**DISAPPROVED  
Plan Review**

**CHILLINO RESIDENCE  
NEW HOME**

11055 GRENADIER DRIVE, WOODLAND PARK, CO 80863

SHEET TITLE:  
**SITE PLAN**

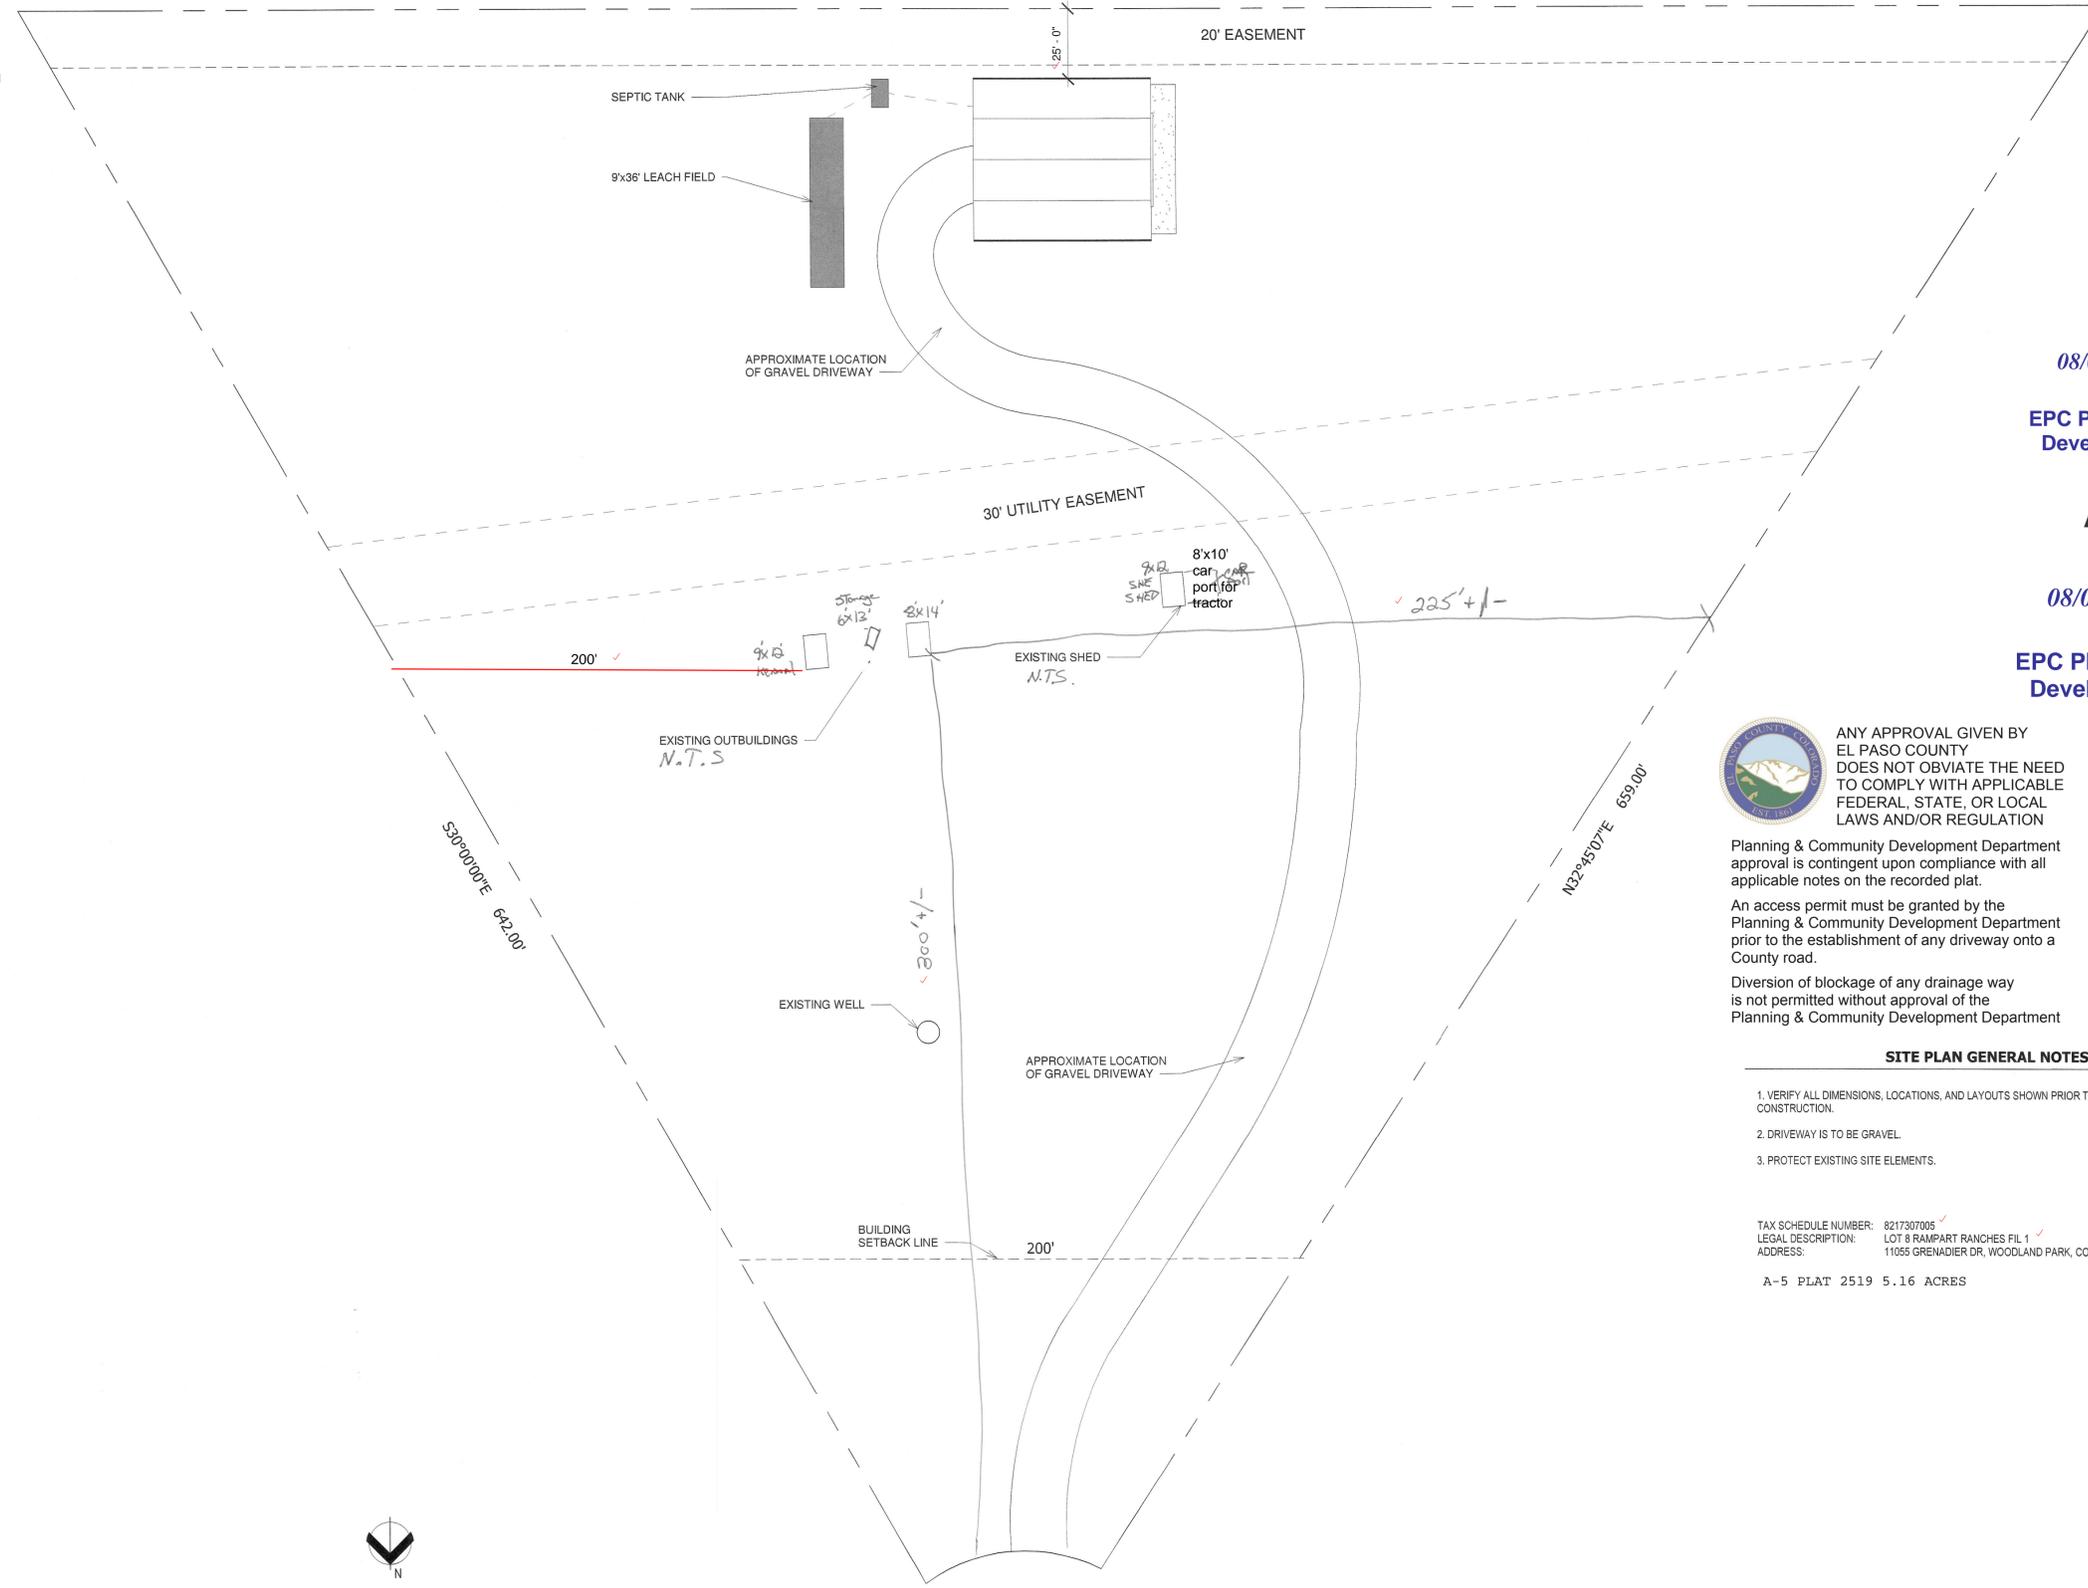
**EXISTING STRUCTURES MUST  
ACCURATELY DEPICT CURRENT  
STRUCTURES ON THE PARCEL.  
SHOW DIMENSIONS OF EACH  
STRUCTURE AS WELL AS IDENTIFY  
THEIR USE, DIMENSIONS TO  
PROPERTY LINE AND OBTAIN A  
BUILDING PERMIT FOR EACH  
STRUCTURE IF ANY OF THE  
STRUCTURES ARE OVER 200 SQFT.**
